Jeffrey J. Moss, P.E.
Senior Structural Engineer

Re: Structural Investigation
58 Bass Hound Circle
Fuquay-Varina, NC 27626
Project #23148

PHOTO 1

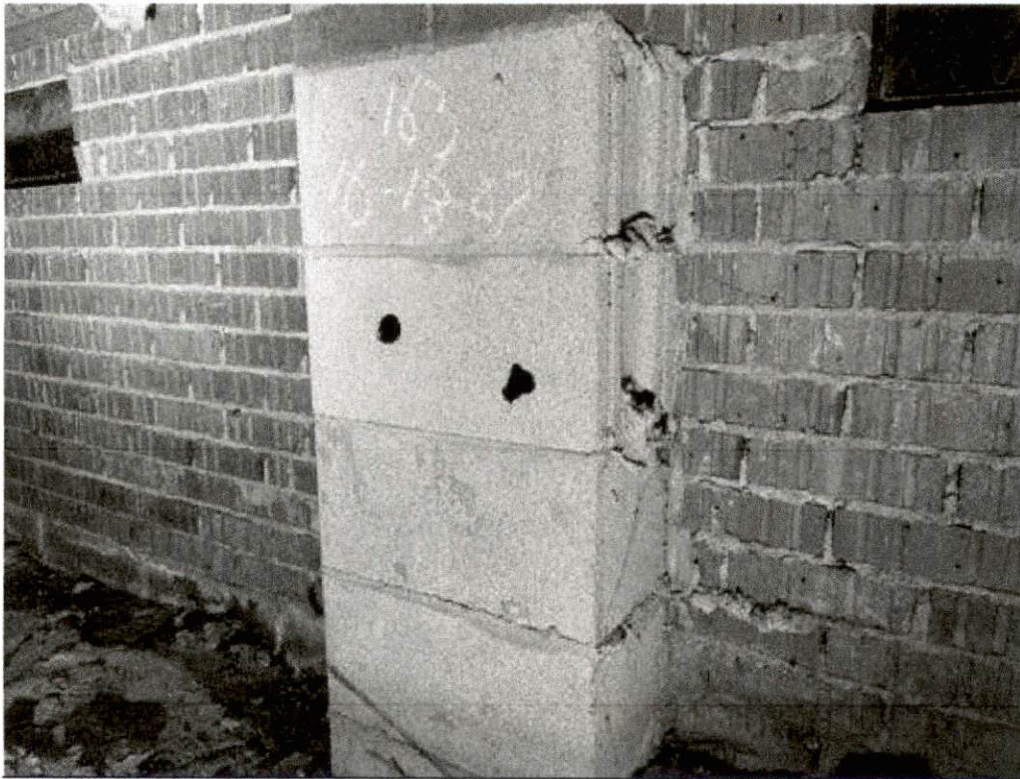
- There were holes in the block piers at the perimeter of the crawl space (photos 1 & 2).
- The girder at the rear has two areas of termite damage (photos 3 to 6).
- The area under the tub has wood rot damage in the floor sheathing and floor joists (photo 7).
- New floor joists were “sistered” to each side of the existing floor joists in this area (photos 8 & 9).
- The floor sheathing wasn’t repaired.
- There was blocking added between the floor joists. At least one of the blocking pieces was framed into an existing floor joist with wood rot.

The holes in the block piers are minor and not a structural issue at this time.
